**WELWYN HATFIELD BOROUGH COUNCIL  
EXECUTIVE DIRECTOR - PLANNING, PUBLIC PROTECTION AND GOVERNANCE**

**DELEGATED APPLICATION**

**Application No:** 6/2021/1405/FULL  
**Location:** 49 Mulberry Mead Hatfield AL10 9EH  
**Proposal:** Erection of two storey rear extension, single storey side extension, front porch, loft conversion with the installation of 1 x front dormer and 1 x rear juliet balcony and alterations to fenestration  
**Officer:** Ms Louise Sahlke

**Recommendation:** Refused

| Drawing No. | | 49MMH/PD/401 | |

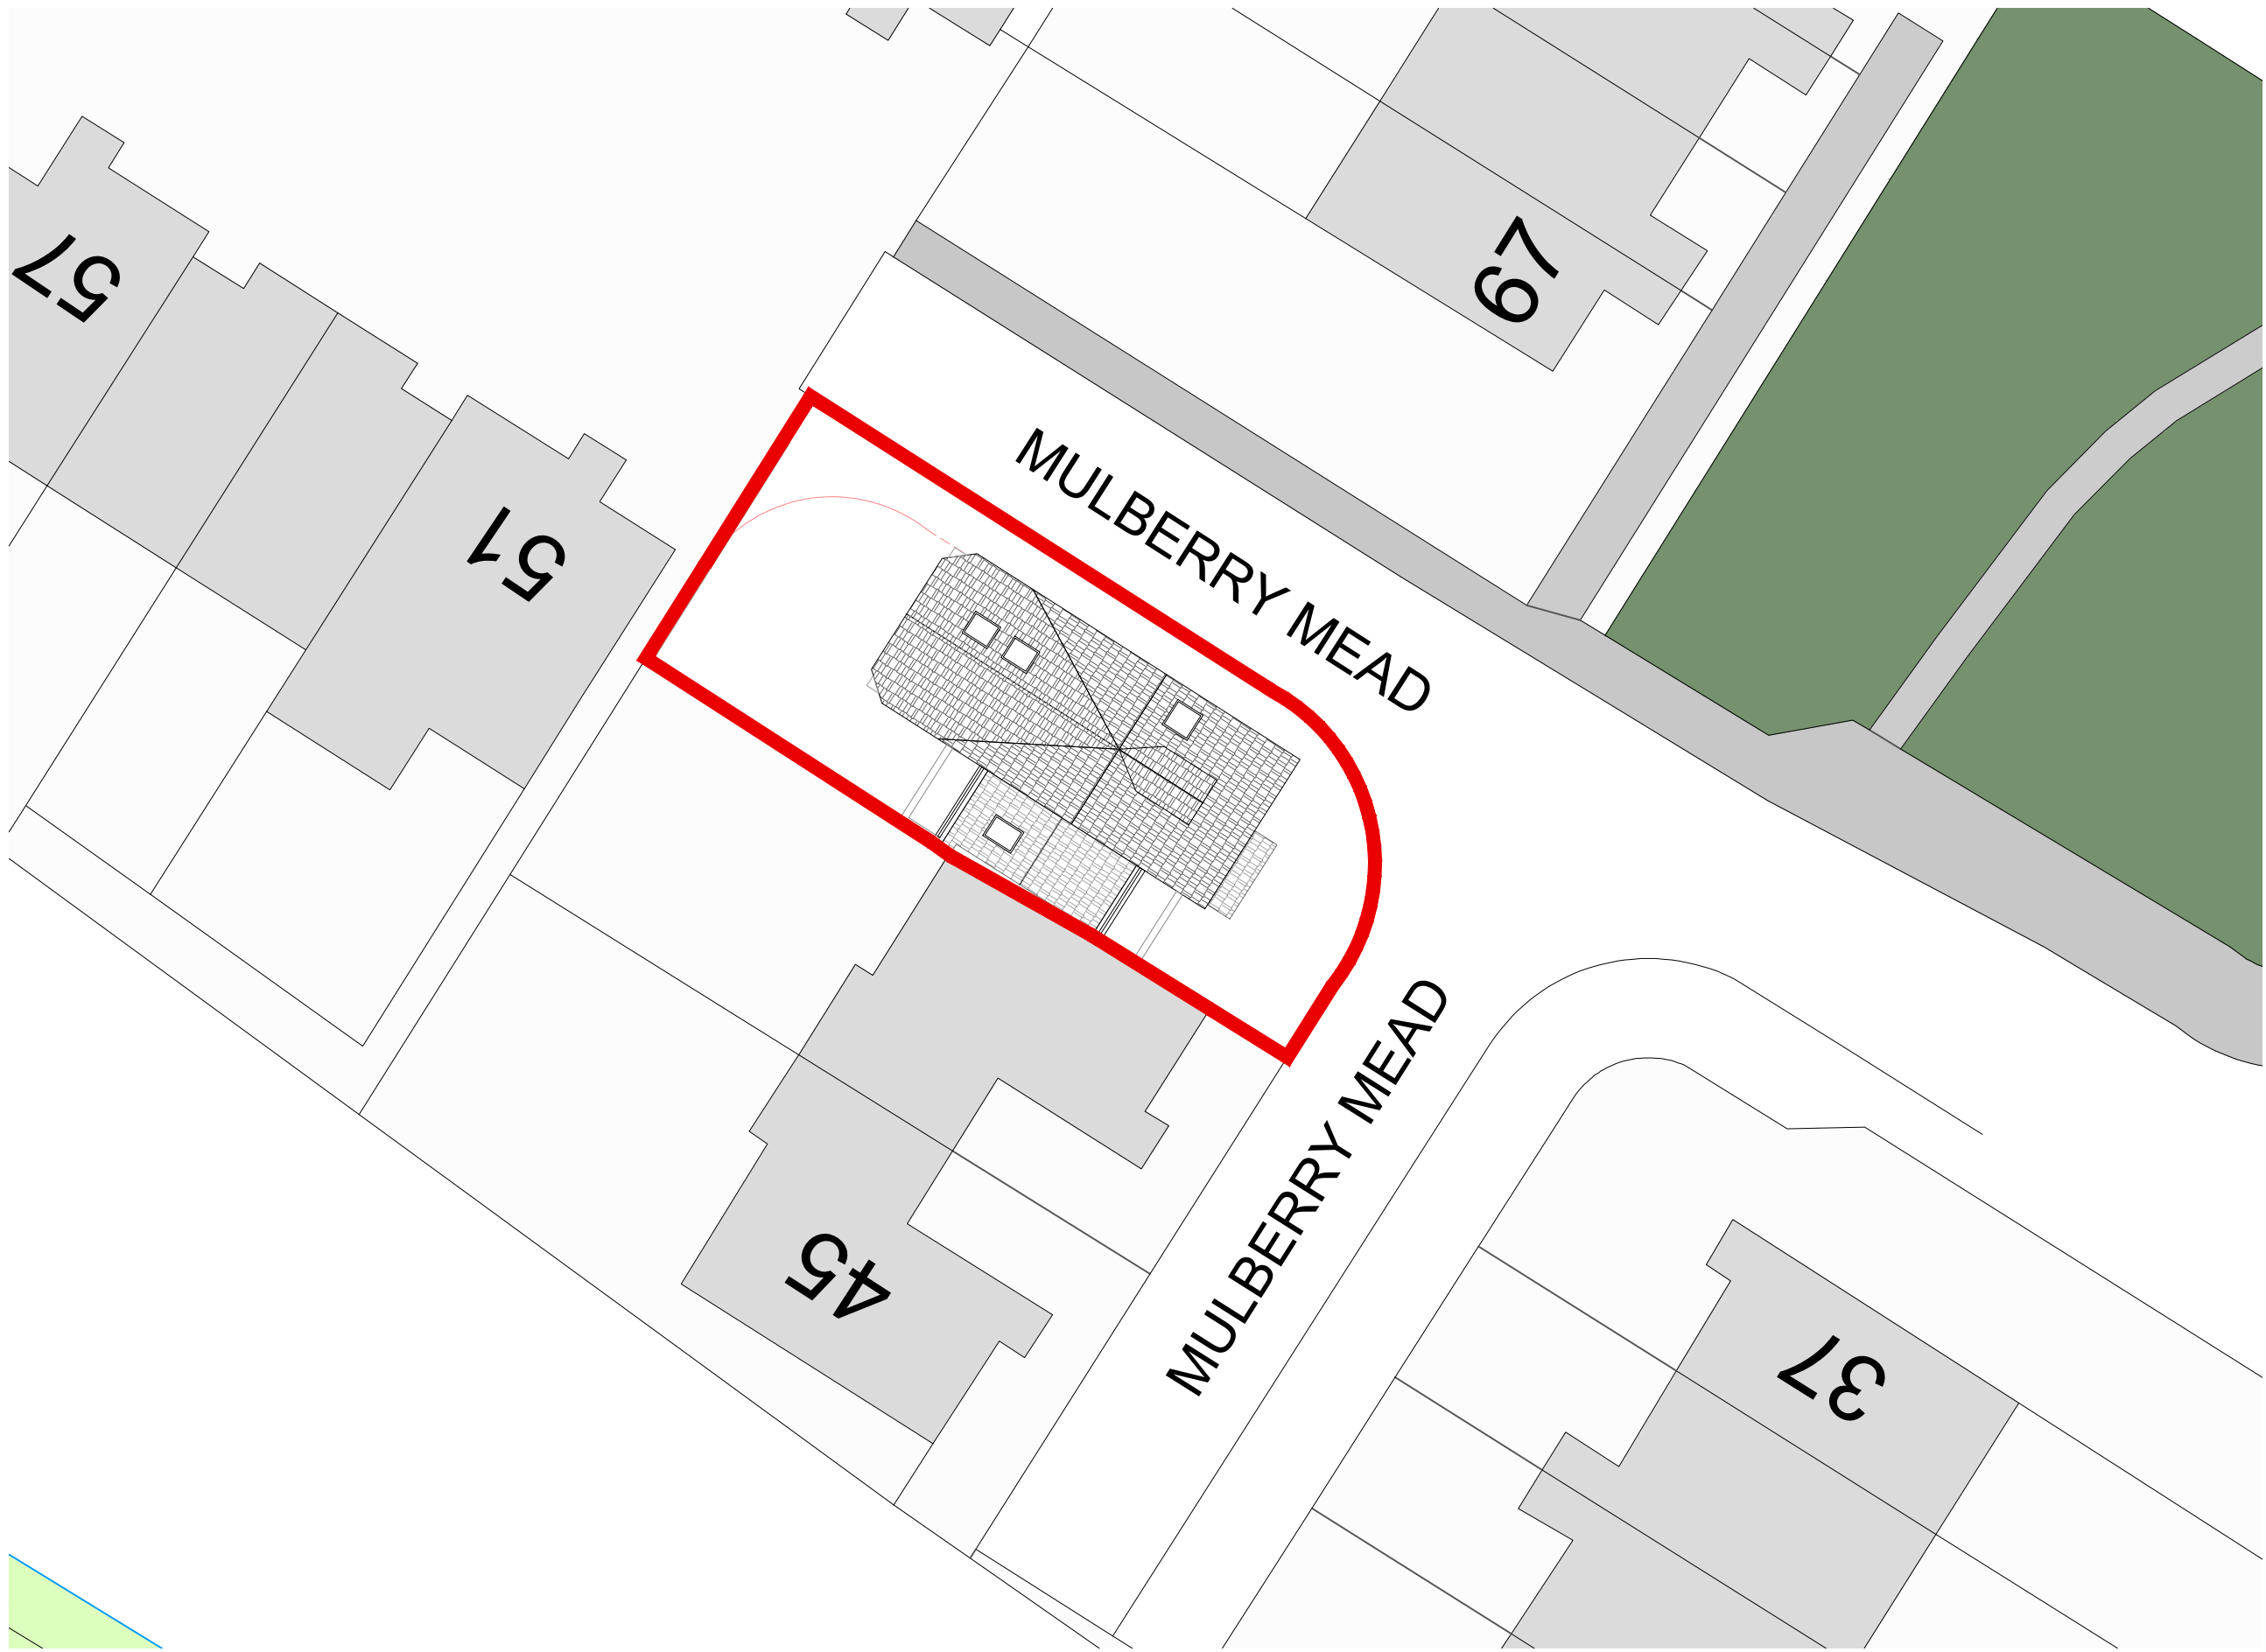
In addition to the above, the proposal also seeks to erect an area of fencing following part demolition of the existing boundary wall. The application describes the fence as being “for access”, however, there are no details of gates, a crossover, a dropped kerb, or hardstanding to facilitate access. The proposed plans show a fence which would match the height of the existing wall.

The erection of a fence is generally not an unacceptable form of development in a residential setting, especially where similar examples of hard boundary treatments are witnessed nearby. However, each proposal must be considered on its merits and whilst existing boundary treatments are a material consideration, there are localised differences in the character, appearance and the function which they serve. In this case it is proposed to demolish an existing curved wall and to erect a replacement fence, which would have the effect of squaring off a corner of the rear garden serving the application dwelling by enclosing an area of soft landscaping which is currently open the street. It is considered that the proposal would represent poor quality design which would cause harm to the character and appearance of the area. This is because the existing wall is a positive feature which serves to enhance the character and appearance of the area. Its curved design adds interest, provides space for a street tree and affords visual relief to what would otherwise be a prominent corner when viewed from the street and the properties to the north west of the site. In comparison, the proposed fence would be of a lesser quality in term of materials and its siting would result in the enclosure of soft landscaping which has a public amenity value. In this regard the original design of the housing estate was carefully considered to provide a balance of soft and hard landscaping. Soft landscaping, such as front gardens, grass verges and street trees contribute to the quality of the area. Although the area of soft landscaping affected by the proposal is limited, its enclosure would nevertheless have a deleterious impact on the character and appearance of the area. Overall, by reason of its siting and design, the proposed fence would appear unduly dominant within the streetscene.

3. The proposed boundary fence, by reason of its siting and design would appear unduly dominant within the streetscene. Added to this harm would be the enclosure of an area of soft landscaping which would have a deleterious on the visual amenity, character and appearance of the area. Accordingly, the proposal would represent a poor quality of design and would be contrary to provisions of the Policies D1 and D2 of the District Plan 2005; Supplementary Design Guidance 2005; and the National Planning Policy Framework.

<p>parking provision that accords with the planning policies and the guidance in the SPG and the Interim Policy referred to earlier, then the cumulative effect would be harmful to highway safety and the character and appearance of the surrounding area.</p> <p>Therefore the proposal fails to provide adequate on-site parking to accommodate the proposed development resulting in increased levels of car parking resulting in harm to the safety and operation to the public highway. Accordingly, the proposal fails to comply with Policies D1, D2 and M14 of the District Plan 2005, the Supplementary Design Guidance 2005, the Supplementary Planning Guidance on Parking Standards 2004 and the National Planning Policy Framework.</p>
<p><b>Any other considerations</b></p>	<p><u>Flood zone surface water 1000</u></p> <p>Part of the application site is located within the above constraint. However due to the small scale of development, it is considered that no further details are required in terms of flood protection of the proposed extension.</p>

1. The proposal fails to provide adequate on-site parking to accommodate the proposed development. Accordingly, the proposal fails to comply with Policies D1, D2 and M14 of the Welwyn Hatfield District Plan 2005; the Supplementary Design Guidance 2005; the Supplementary Planning Guidance on Parking Standards 2004; and the National Planning Policy Framework.
